Rezoning Transportation Analysis

Petition Number: 2020-014

Revision Log:	Date	Description
	02-24-20	First Review

PROJECT #: DATE: 12-13-19
 DRAWN BY: PC CHECKED BY: PC
 TITLE
Site Plan
 SHEET NO.
RZ-1

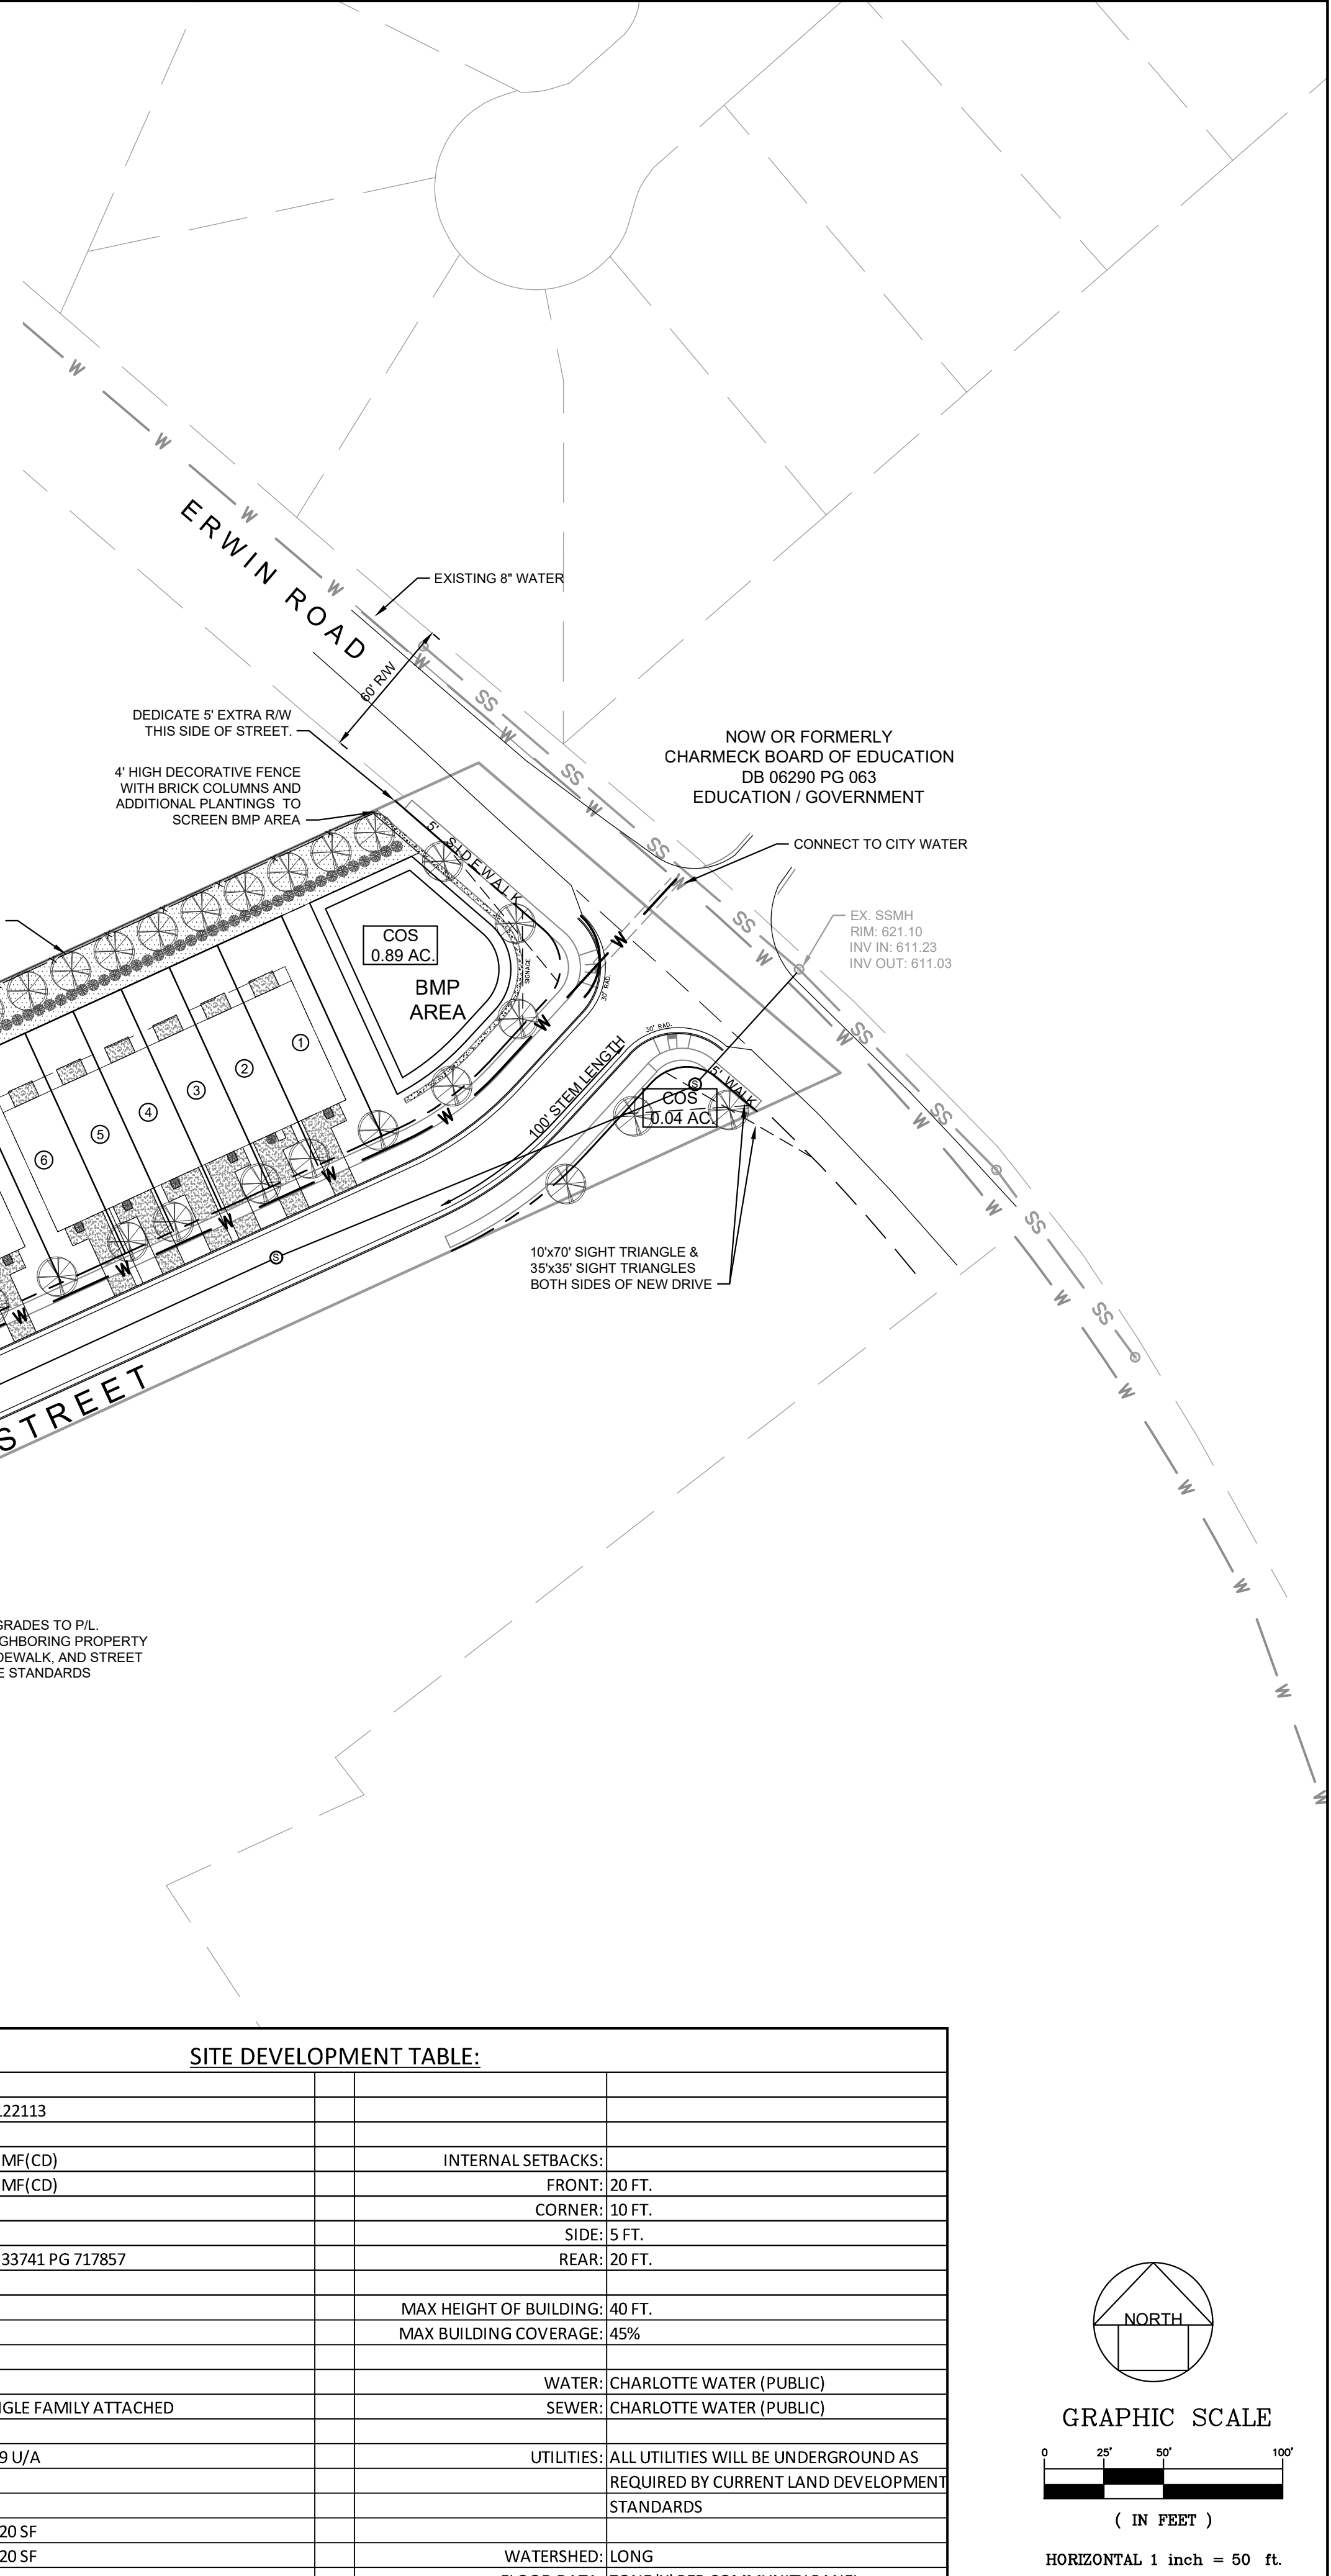
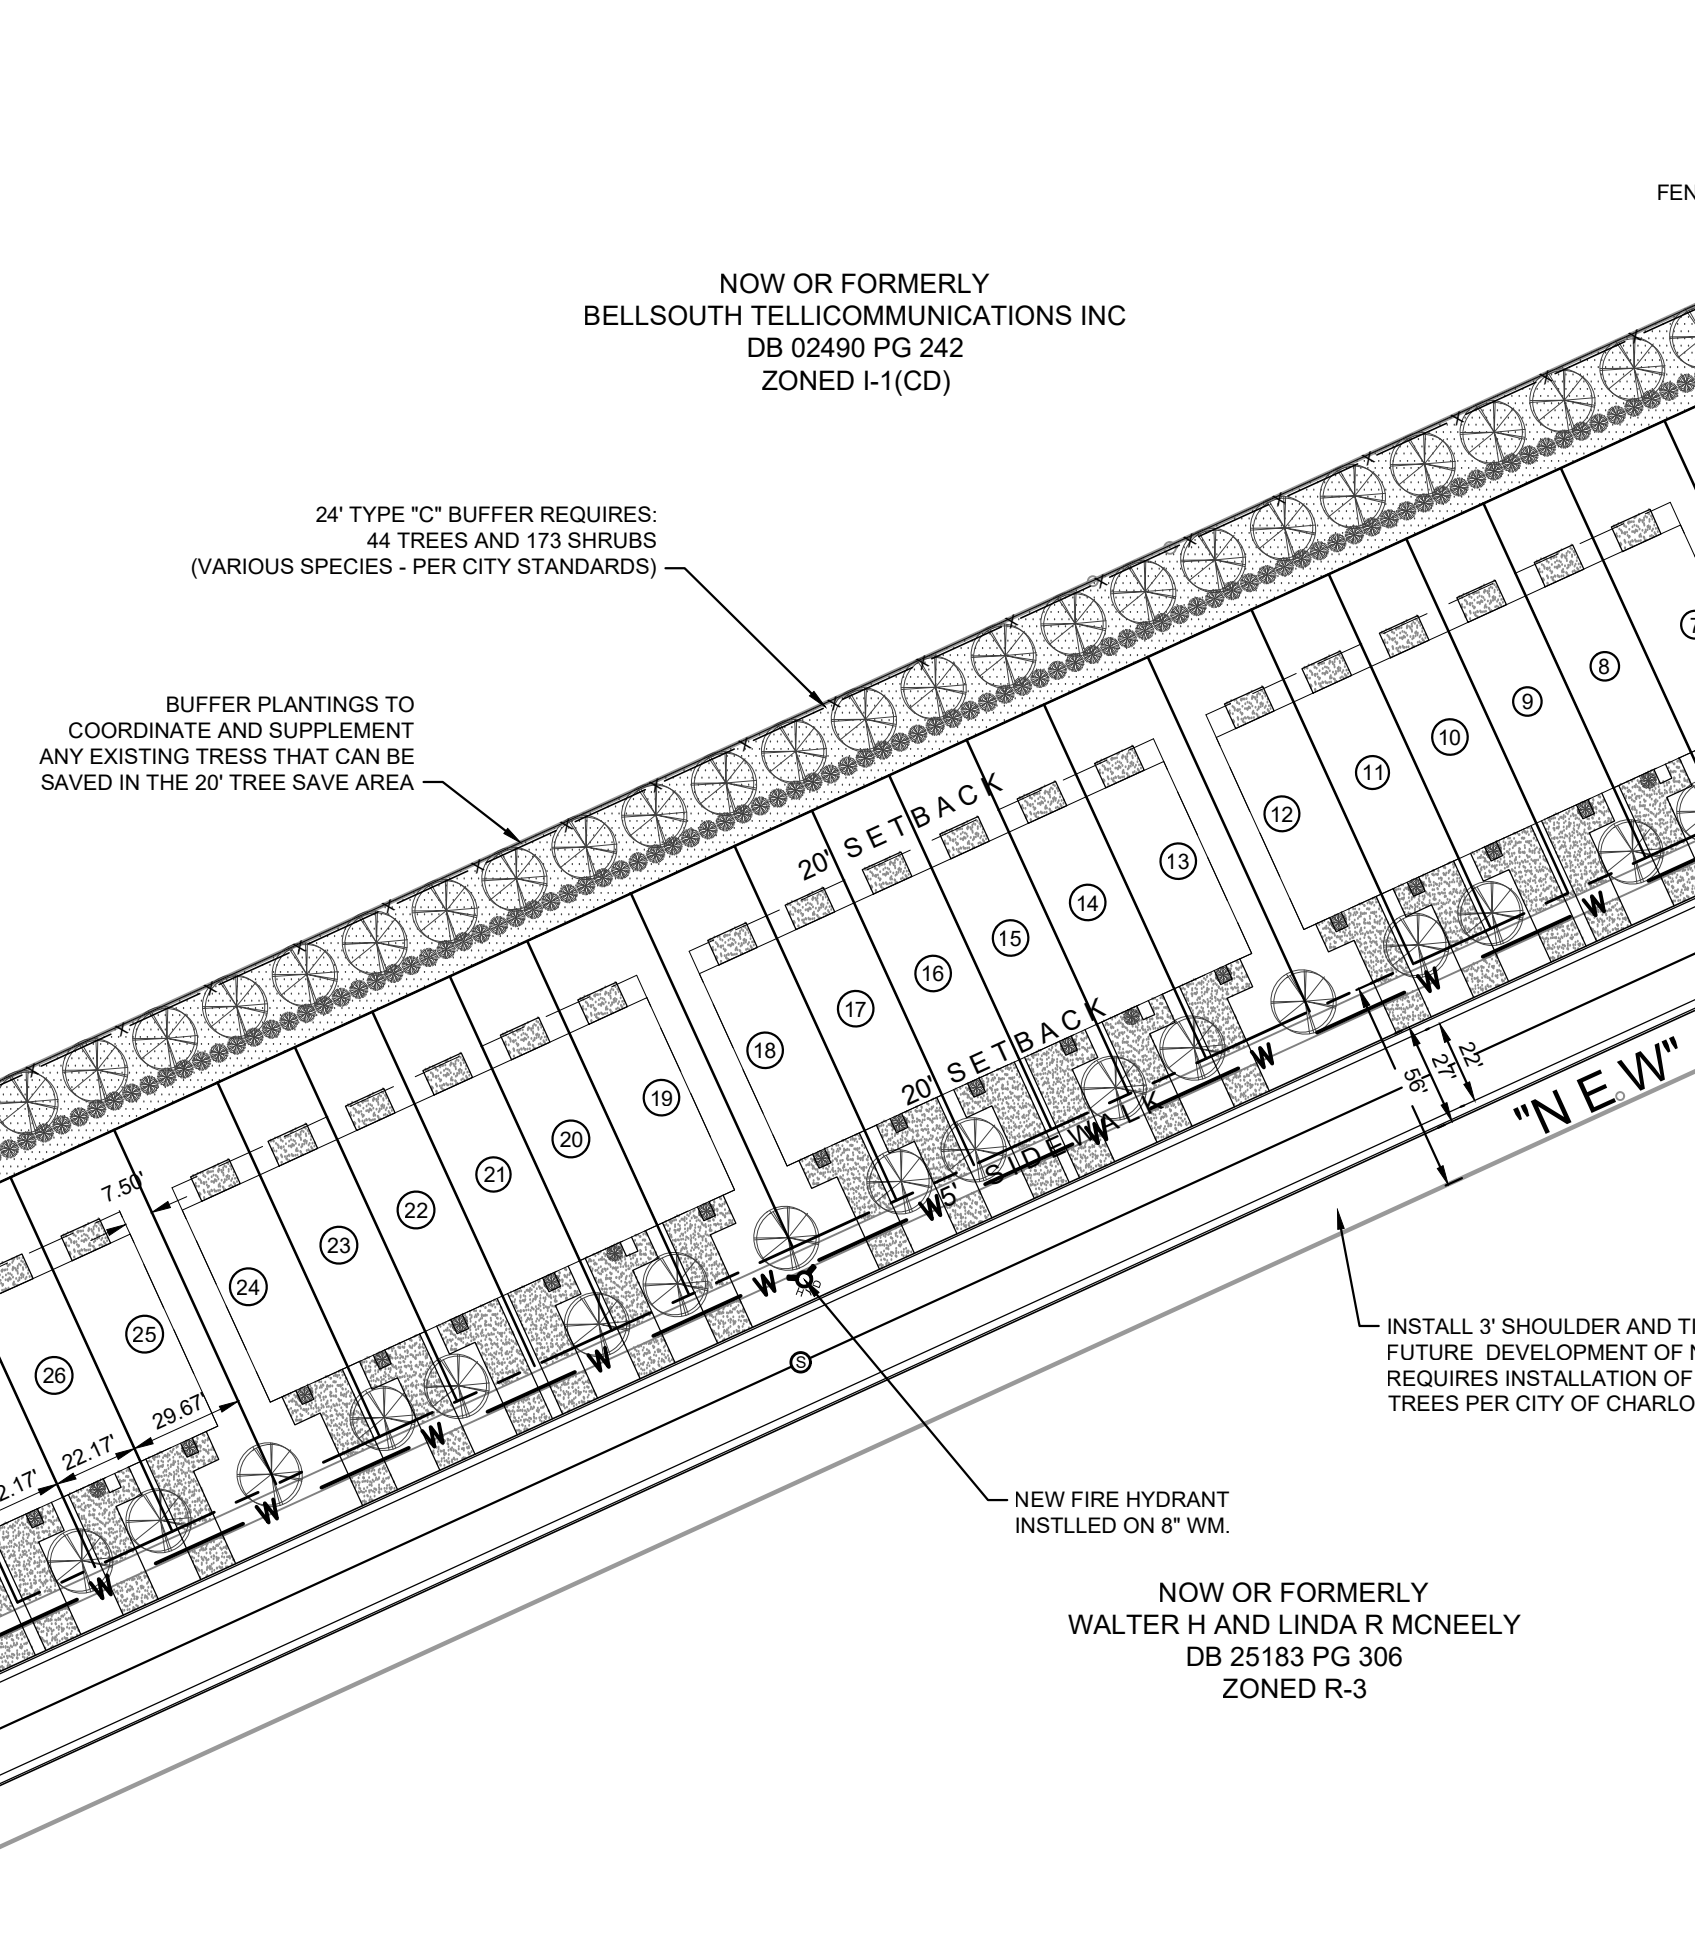
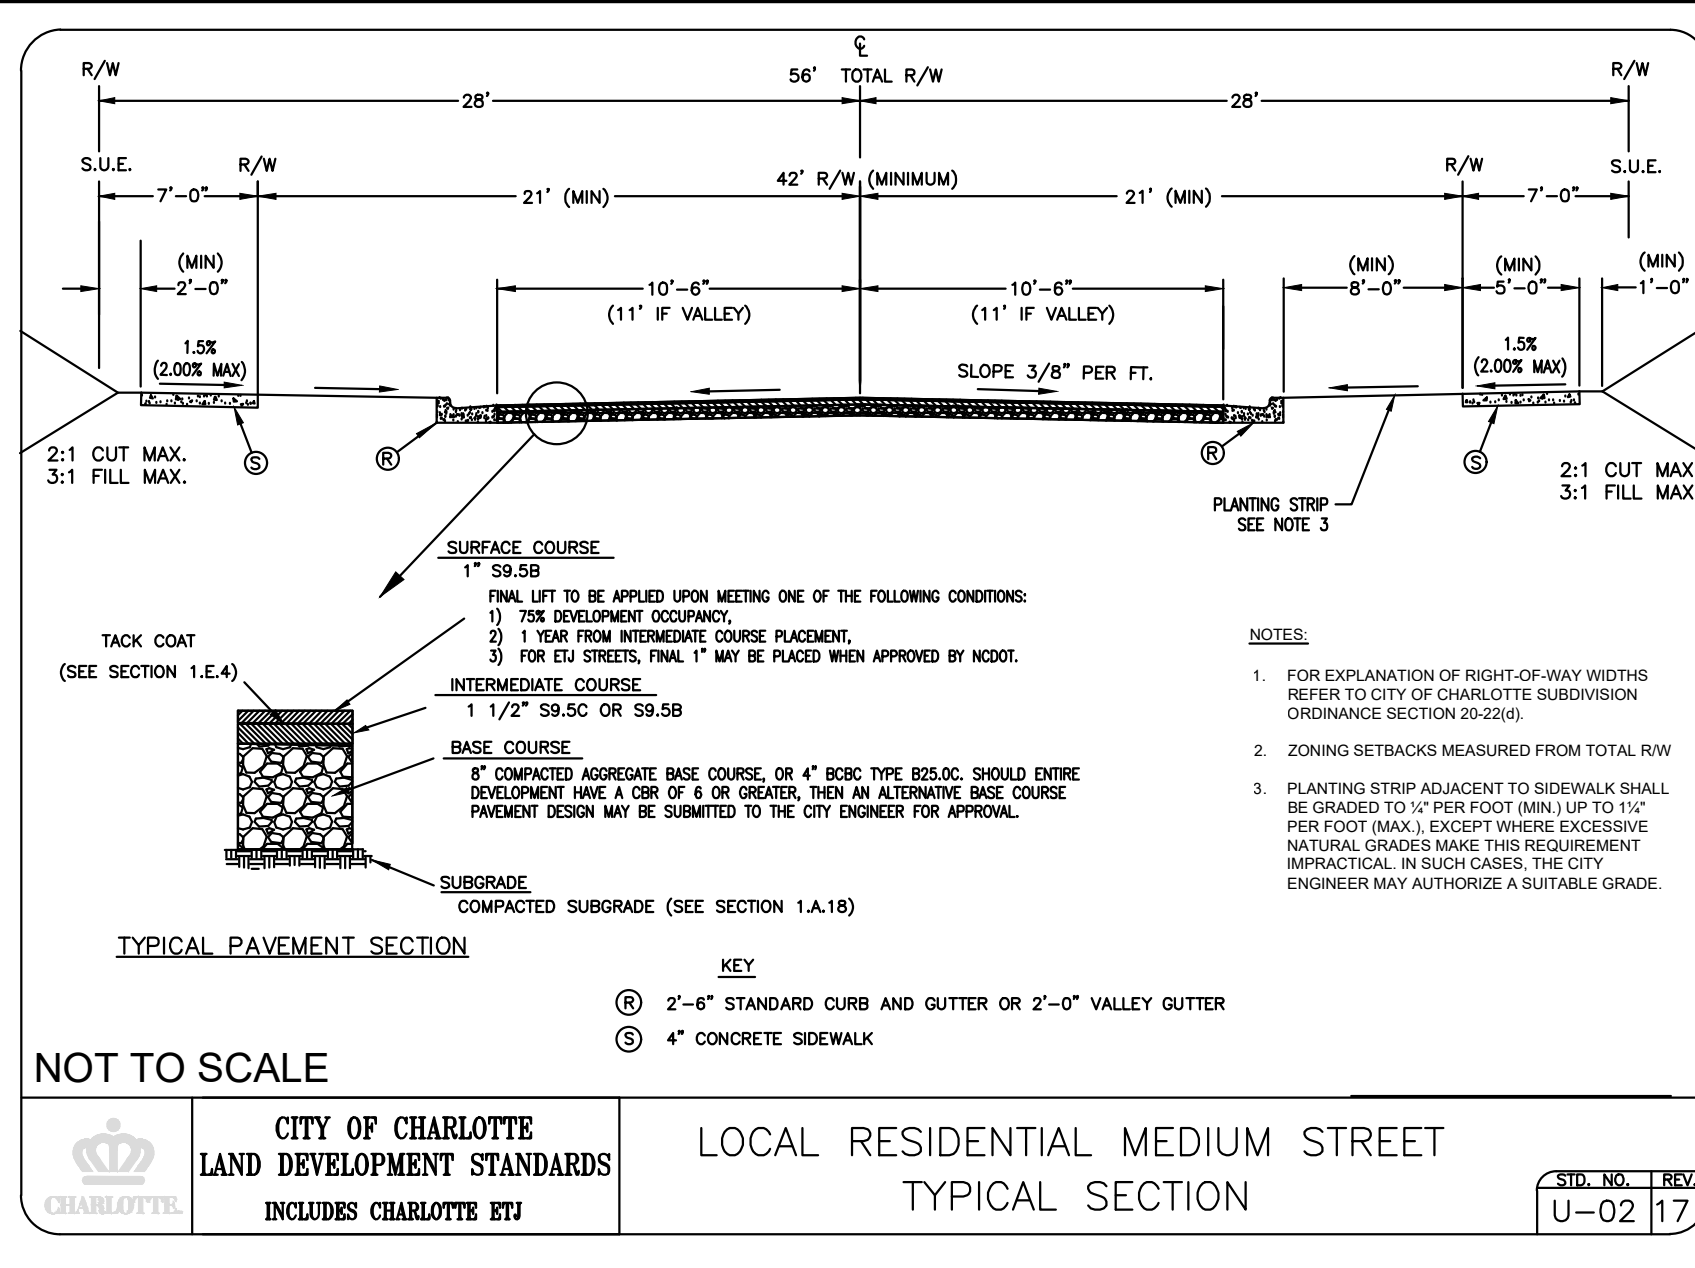
- a. **Erwin Road:** The future location of curb and gutter is 24 feet from centerline of the road. The petitioner should revise the site plan and commit to construct the curb and gutter at its ultimate

location. The site plan should revise the site plan to label and dimension the curb and gutter from the road centerline.

3. The petitioner should revise the site plan and conditional note(s) to commit to dedicate 35 feet of right-of-way from the road centerline, as required within Chapter 12 of the Zoning Ordinance for a CRTPO classified minor thoroughfare. The site plan should label and dimension the right-of-way from the road centerline.

4. The petitioner should revise the site plan and conditional note(s) to dedicate the proposed "New Street" as a proposed public street, per the Subdivision Ordinance.

5. The petitioner should revise the site plan and conditional note(s) to include 25 mph speed limit signs, as part of the Charlotte WALKS and Vision Zero council-adopted policies.

6. The petition should revise the site plan and conditional notes(s) to include a stop bar and stop sign at the proposed intersection of the "new" street & Erwin Road intersection.

7. The petitioner should revise the site plan and conditional note(s) to commit to construct two directional ramps on each corner of the intersection, per Section R207 of PROWAG, of Erwin Road & the proposed street.

8. The petitioner should revise the site plan and conditional note(s) to commit to construct a signalized pedestrian crossing to the Lake Wylie Elementary school.

9. The petitioner should revise the site plan and conditional note (Section 3. Access and Transportation.b.) to commit to construct an 8-foot planting strip and 6-foot sidewalk along Erwin Road, per Chapter 19 of the Charlotte City Code. The site plan should label and dimension both items from the back of curb and gutter and road centerline.

10. The petitioner should revise the site plan and conditional note to complete the connection with the adjacent proposed street within the site plan recently approved within rezoning petition 2019-030.
